REPORT UPDATE

Application No: AL/64/20/PL

Recommendation Report for Planning Permission

PROPOSAL: Demolition of the existing dwelling & construction of 2 no. 2-bed. 3 no. 3-bed, 4 no.

Drainage Strategy				Draining The
Engineering Details				
Drawn	Checked	Scales	Paper Size	Date
JN		1:250	A1	08.19
Job No.				Revision
KNC/1932	602-01			C

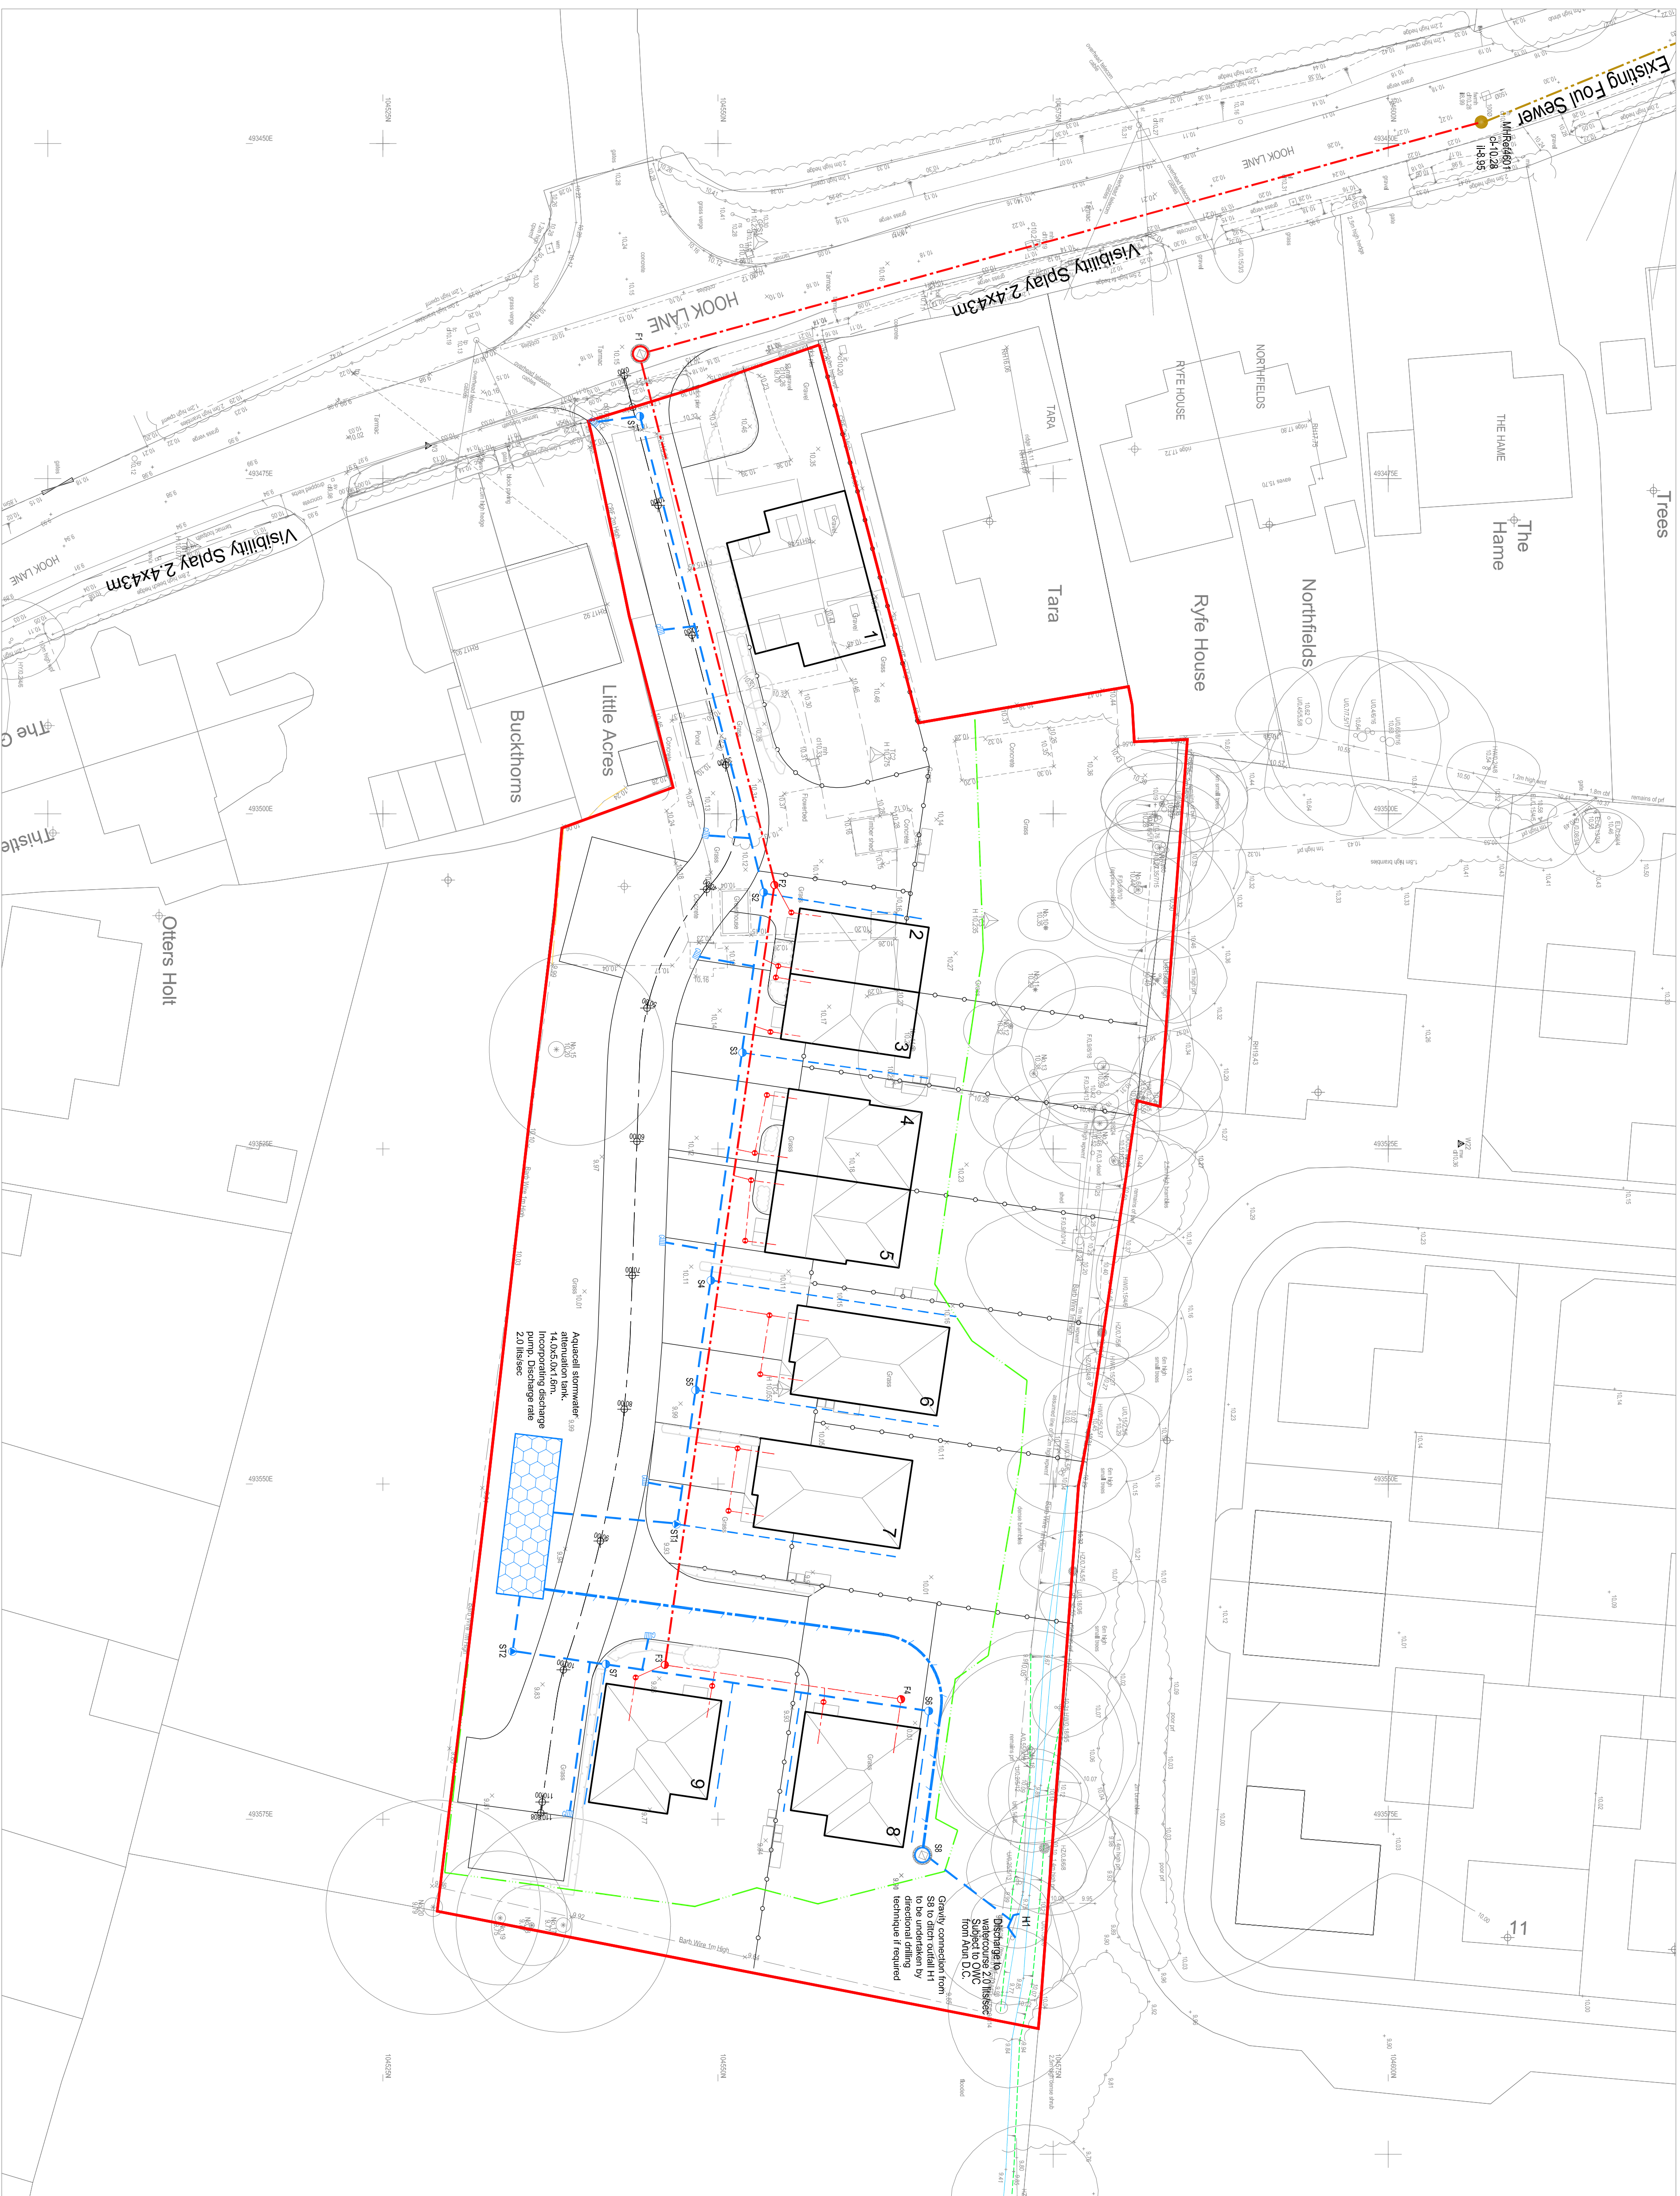
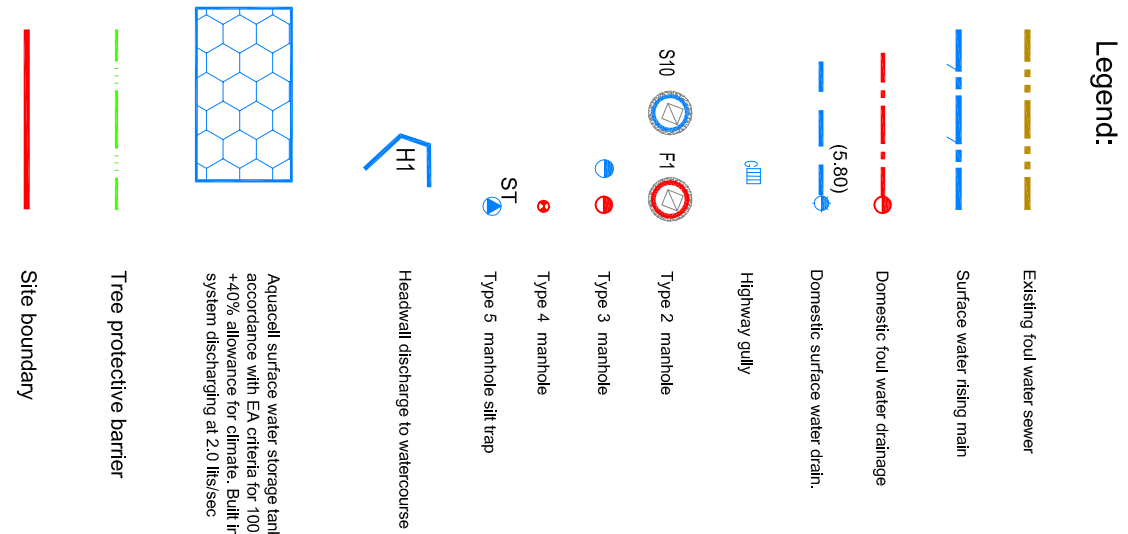
- Concerned with the route of surface water discharge to the north boundary watercourse and construction of the headwall - both in the RPA of a retained (off-site) mature Cypress (T21). Either the route of the drainage connection be changed or directional drilling employed to protect the roots here;

- Pumping is not sustainable and gravity options must be fully explored;
- The applicant should consider the significant use of permeable paving and other shallow features to convey and store water across the site, whilst minimising the use of pipework;

- The applicant should fully survey the ditch and its outfall, as this will impact any design;
- It may be necessary for the applicant to undertake further works to this ditch to reduce bed levels where possible, in order to aid a gravity solution;

- The conflict between the drainage scheme and the existing trees needs to be resolved; and
- The layout does not address the requirement to keep boundary fences at least 3m away from the banks of the northern boundary ditch in order to allow for future maintenance including allowing access by vehicles. This matter must be resolved before the layout is agreed.

The line of the ditch and its respective banks are indicated on the preliminary drainage plan. Using this it is possible to approximately calculate garden depths should it not be possible to use demountable fencing and instead have a rear boundary set 3m back from the ditch. This would mean that plots 4 & 5

ADC TREE OFFICER - The applicant has amended the Arboricultural Impact Assessment & Method Statement to state that if significant roots are present along the line of the drainage channel then directional drilling will be used to avoid major roots. A landscaping condition will specify that tree planting should be on a ratio of 2 for every 1 lost and should include native species of potential stature.

The layout would allow for access to be taken through the parking area of plot 8 provided that demountable fencing was then used to enable access from there to the ditch. The presence of separate legislation means that this can be agreed at a later date and if it proves not possible to secure the necessary easements/vehicular maintenance access then the applicant would need to submit an application for a new layout. It is proposed to add the following informative:
